From: Simon Davis
Sent: 29 January 2025 09:40
To: Gary Morris [REDACTED]
Cc: Edward Jenkinson [REDACTED] Rachel Alderson <Rachel.Alderson@arun.gov.uk>; Joshua Reid [REDACTED] David Easton <David.Easton@arun.gov.uk>
Subject: RE: A/222/24/PL Sports Hub - Ecology

"I see that the site to the north (A/122/19/OUT) has a condition for the developer to deliver a signalised crossing just south of the primary school on Arundel Road. This is in very close proximity to the proposed site access works proposed for the above application. It says the crossing should be delivered by the 80'th occupation of the new residential units. Could you confirm how far off this is please, do you know how many are already built out and how many are occupied? So, I can gain an idea of when this is likely to be put in place.

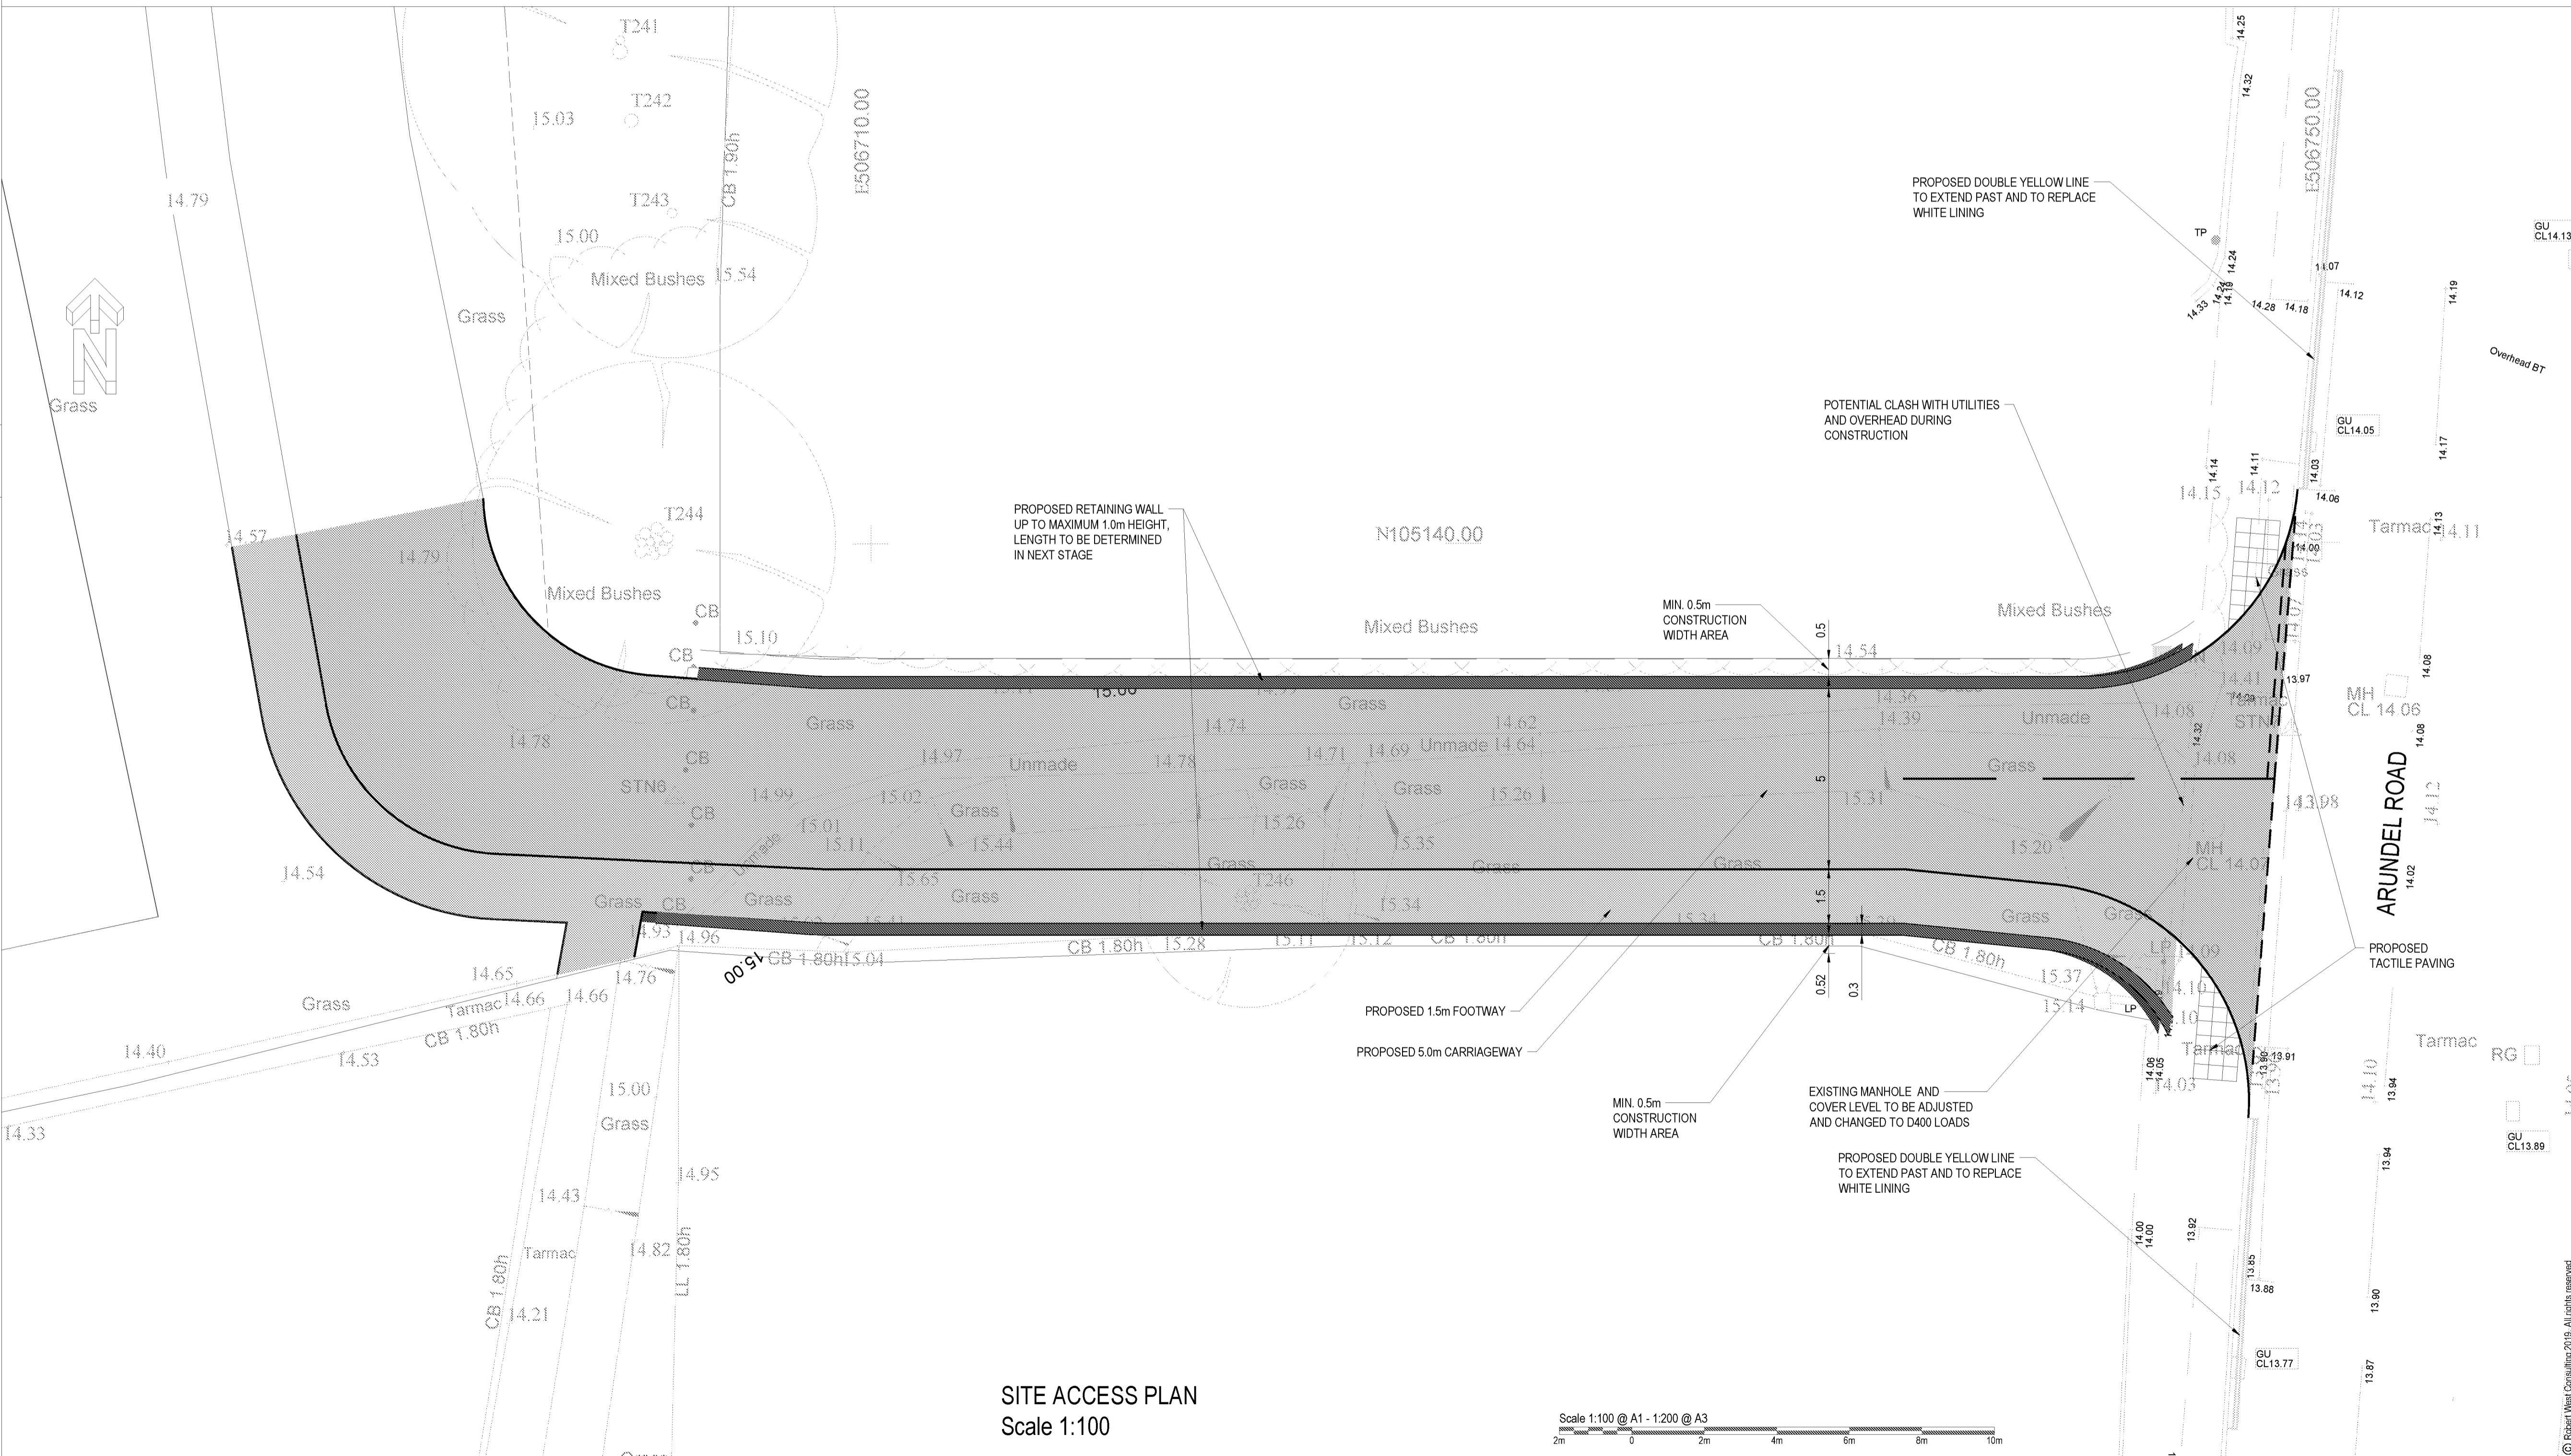
I have reviewed the application now, but we will need for the Safety Auditor to be made aware of the signalised crossing that is secured and going to be in place given its proximity to the new access point for the Angmering Sports Hub, I would need the following provided –

- *A new site access plan that also details the secured signalised crossing point and the proposed new access, with the proposed parking restrictions (double yellow lines) included on the plan, that the Safety Auditors have recommended.*

- A revised/updated Stage 1 RSA that confirms that the Auditors are aware of the signalised crossing and have reviewed the new access now taking account of the crossing too.
- A RSA Response Report in line with GG 119 Appendix F (see attached) the LHA will require an editable version of this to complete our sections as overseeing authority.
